Ribble Valley Borough Council  
Council Offices  
Church Walk,  
Clitheroe  
Lancashire  
BB7 2RA

Phone: 0300 123 6780  
Email: [developeras@lancashire.gov.uk](mailto:developeras@lancashire.gov.uk)  
Your ref: 3/2025/0913  
Our ref: 3/2025/0913/HDC/KW  
Date: 24 February 2026

**Location:** The Rochfords Longridge Road Hurst Green Lancashire BB7 9QW  
**Proposal:** Proposed redevelopment of existing dwelling to include demolition of existing conservatory and single storey side extension; raising the roof height to provide first floor living accommodation; alterations to fenestration and erection of open front porch.  
**Grid Ref:** 368313 437726

SHEET: PROPOSED SITE PLAN

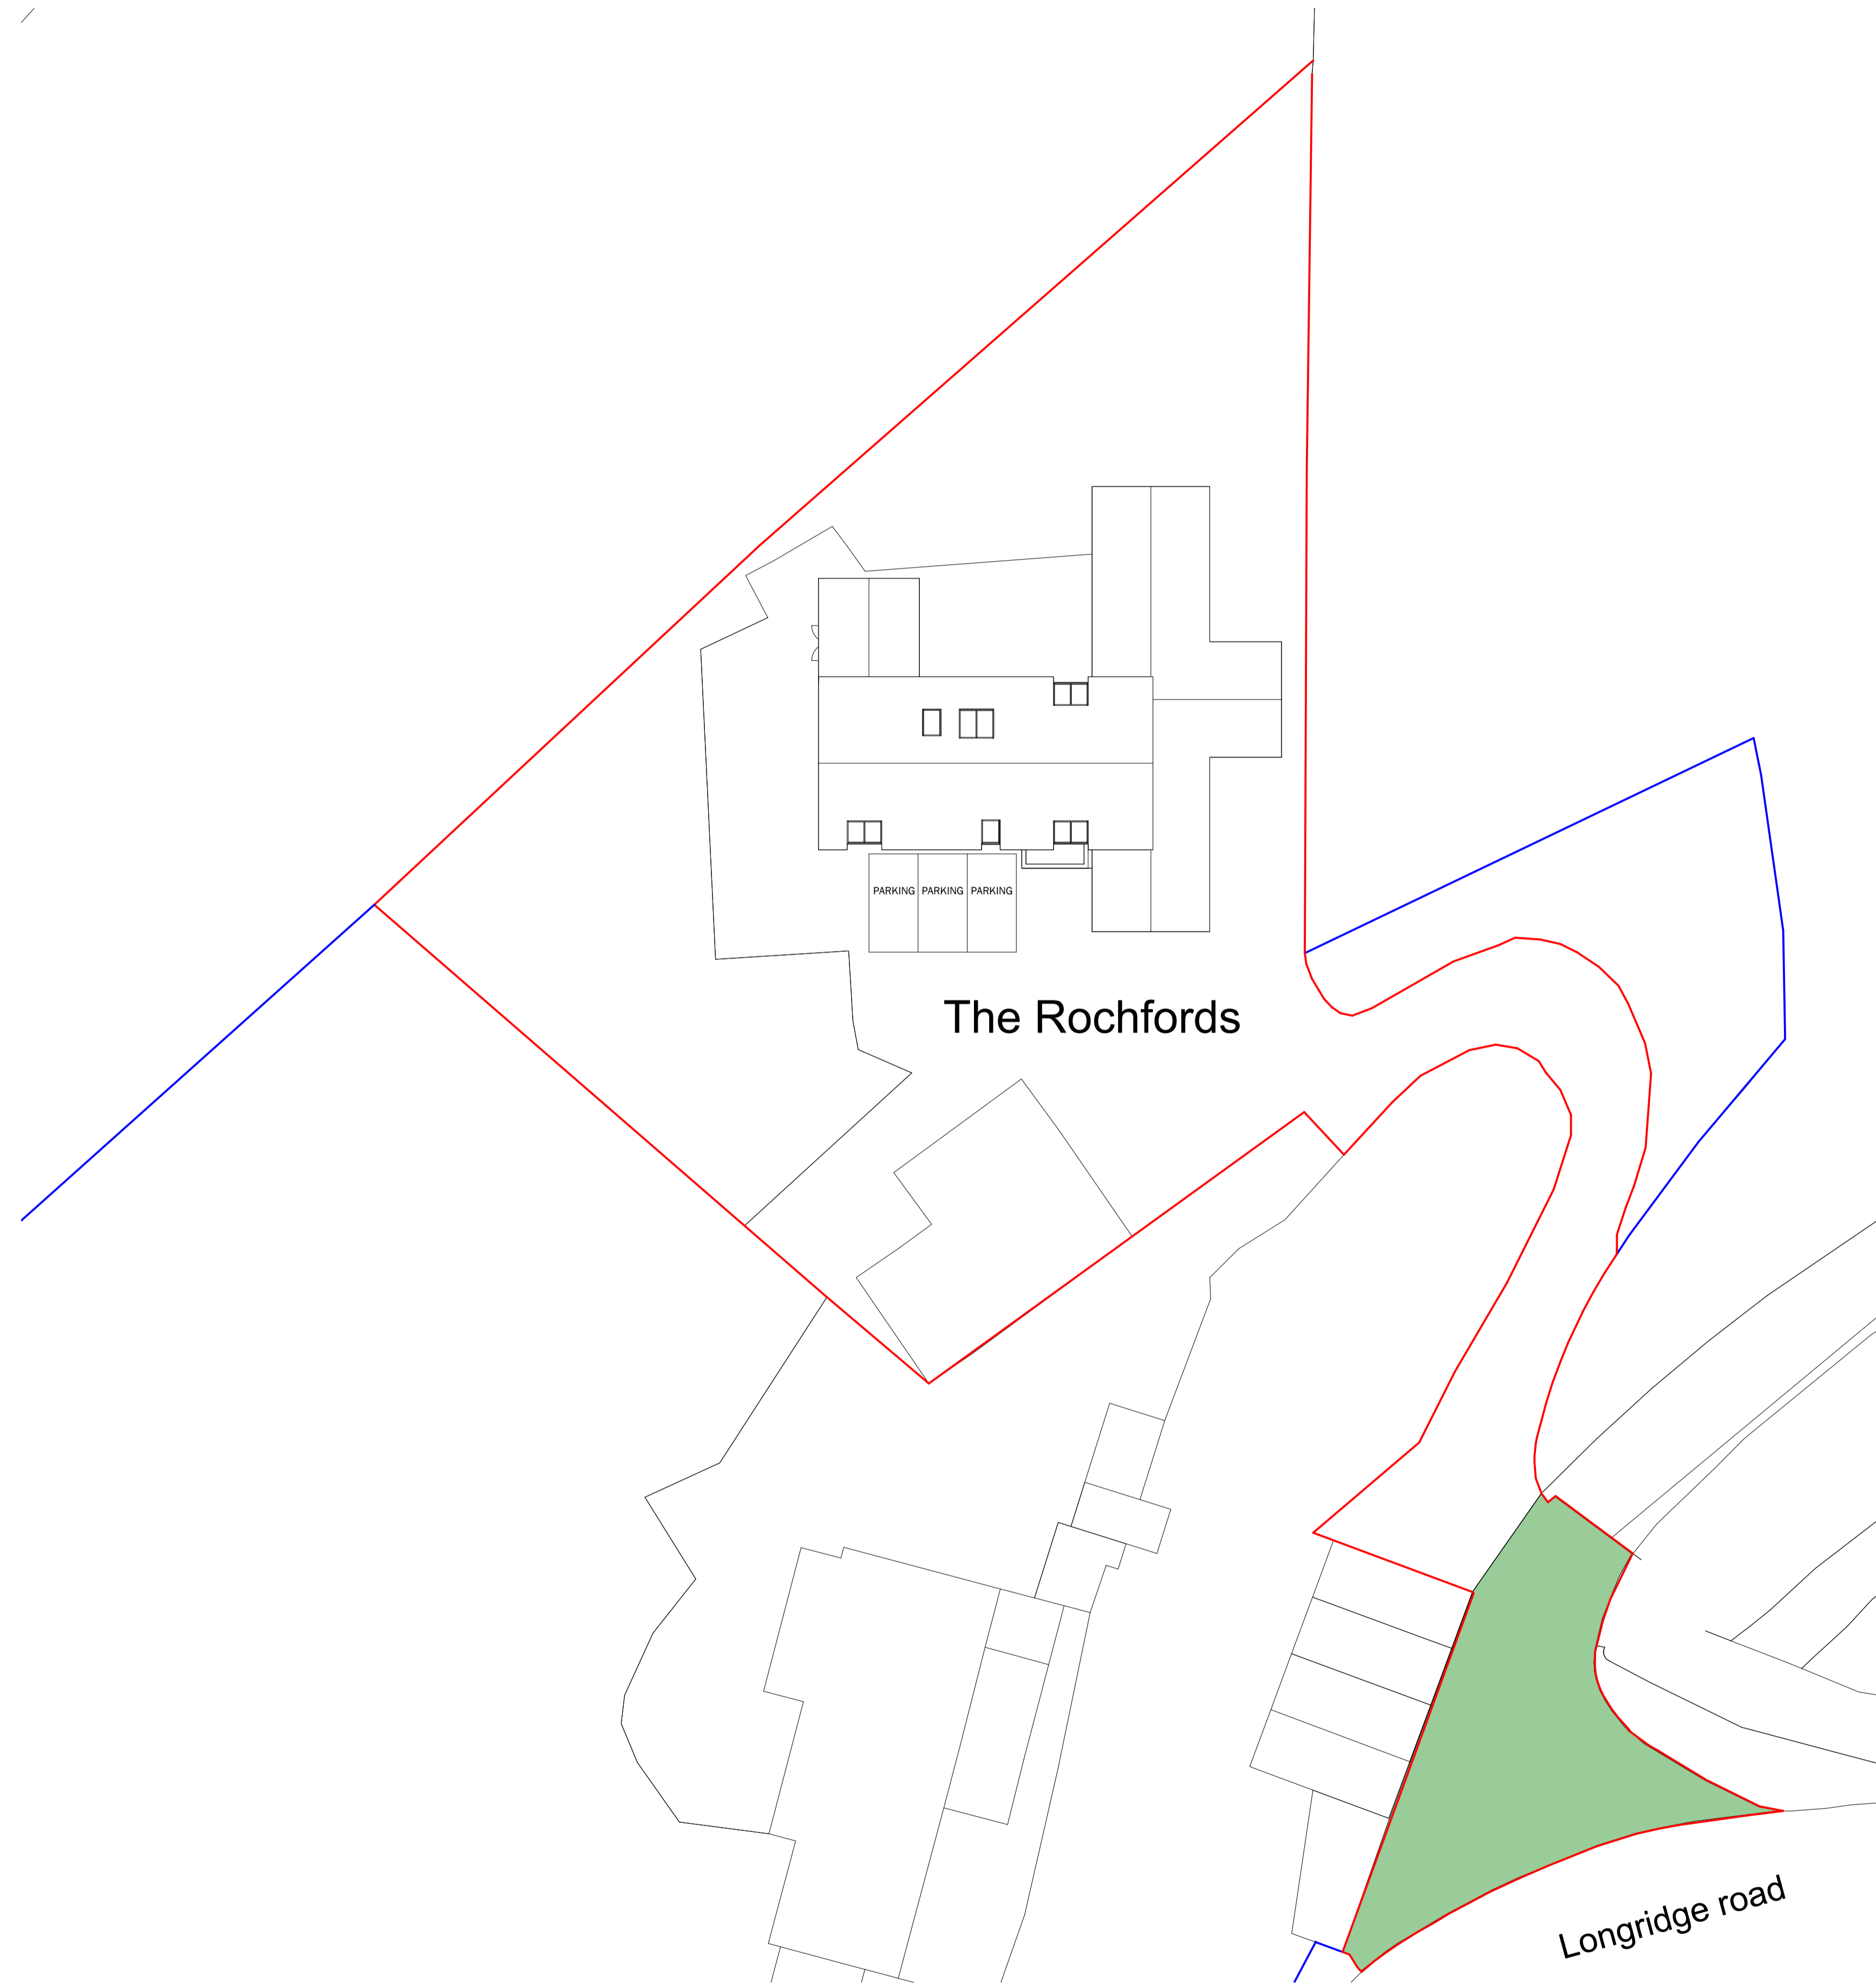
The LHA have reviewed drawing number A1.2 titled "Proposed Site Plan" and are aware that the dwelling complies with the LHAs parking standards as defined in the Joint

Lancashire Structure Plan. There is also room to turn within the site allowing for ingress and egress in forward gear.

The recommended minimum internal dimensions for a single garage size is 6m in length and 3m wide. The recommended distance of 6m is based on the length of a large family car (Ford Mondeo Estate 4.58m long), clearance at the rear of the car (200mm), overhang of the garage door (600mm) and room to stand in front of the car and open/close the garage door (600mm). Where garages are smaller than the recommended minimum internal dimension of 6 x 3m they should not be counted as a parking space.

2. The car parking area shall be surfaced or paved in accordance with a scheme to be approved by the Local Planning Authority. The car parking and manoeuvring areas shall thereafter be kept free of obstruction and available for the parking cars at all times.
